**SYDNEY OLYMPIC PARK AUTHORITY
DESIGN REVIEW PANEL
ADVICE SHEET**

Project	3.1 – Site 9, Proposed Mixed use Development
Presentation / Review Date	3 December 2015
Panel Present	Peter Poulet Bill Tsakalos Caroline Pidcock Peter Mould John Choi Darlene van der Breggen
COI Declaration	None.
Also Present	Ben Woods - SOPA
Presenters	Guy Lake (BatesSmart) Matthew Allen (BatesSmart) Bassam Aflak (Ecove) Michael Azar (Ecove)
Documents made available	Power Point Presentation
Inherited decisions	Special exception to allow for above ground parking
Previous relevant SOPA Advice	DRP meeting 82, 20 March 2014
General Observations/ Overall Comment	<p>The design is for a mixed residential, commercial and retail development, proposed as part of the successful RFDP bid for site 9.</p> <p>The design has been developed in response to the recommendations by the tender assessment team, particularly in relation to the tower form as well as resolution of the ground floor levels. (It was noted that DRP members Caroline Pidcock and Bill Tsakalos had participated in the tender assessment).</p> <p>The DRP was very supportive of the proposed design refinements, including the proposal to increase tower height

Figure 9: Pedestrian wind speed measurement locations with comfort/distress ratings – Podium levels of proposed configuration

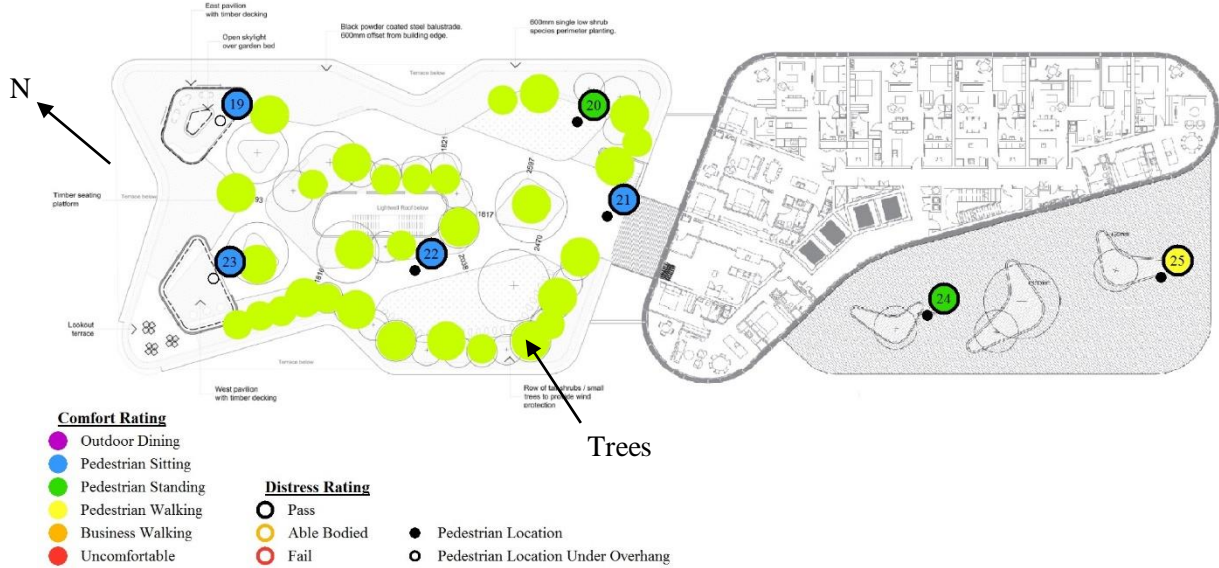
Positives	<p>The DRP commended the 6 star Greenstar target.</p> <p>The DRP supported:</p> <ul style="list-style-type: none"> • Improvements to ground level layout to provide more flexibility for retail / club uses, • Direct OB street address for the residential lobby. • Increased tower height to 36 stories, to enable reduction in tower floor plate area (to 700sm GFA). • Higher proportion of 3B units • Refinements to tower modeling improves slenderness
Issues	<p>The DRP had the following concerns;</p> <ul style="list-style-type: none"> • At 3m floor to floor, the above ground carpark levels will be unsuitable for conversion to other uses at some point in the future. • Proposed indentation to the southern façade needs further consideration in terms of its impact on wind turbulence on the podium

<ul style="list-style-type: none"> the tower cladding is a very sleek 'skin' when a textured approach may be more suitable to mitigate wind turbulence particularly around the re-entrant façade and the core wall. That hard monochrome surface finishes are proliferating at SOP, and that even the proposed terra cotta finishes will not provide enough warmth and colour to alleviate the extensive use of glass and metal claddings. The scale of the colonnade – single storey is too low for a development of this scale and for the Boulevard frontage
Recommendations	<p>The DRP recommends that:</p> <ul style="list-style-type: none"> A wind impact assessment be undertaken, with particular emphasis on coordinating with: <ul style="list-style-type: none"> façade materials and configurations being investigated shape and configuration of the south facing re-entrant façade The southern podium the external material and colour palette should include a greater proportion of warm colour and softer natural finishes. investigate options for increasing the height of the colonnade to 2 storey minimum during the design development phase

Recommended Action	The DRP requested that the above issues be addressed and a further presentation to the DRP prior to lodging the application.
Recommended Supporting Action	The DRP recommended that the colonnade height be reconsidered in the SOP Master Plan 2030 (2015 review).
Circulation of Advice	SOPA, proponents
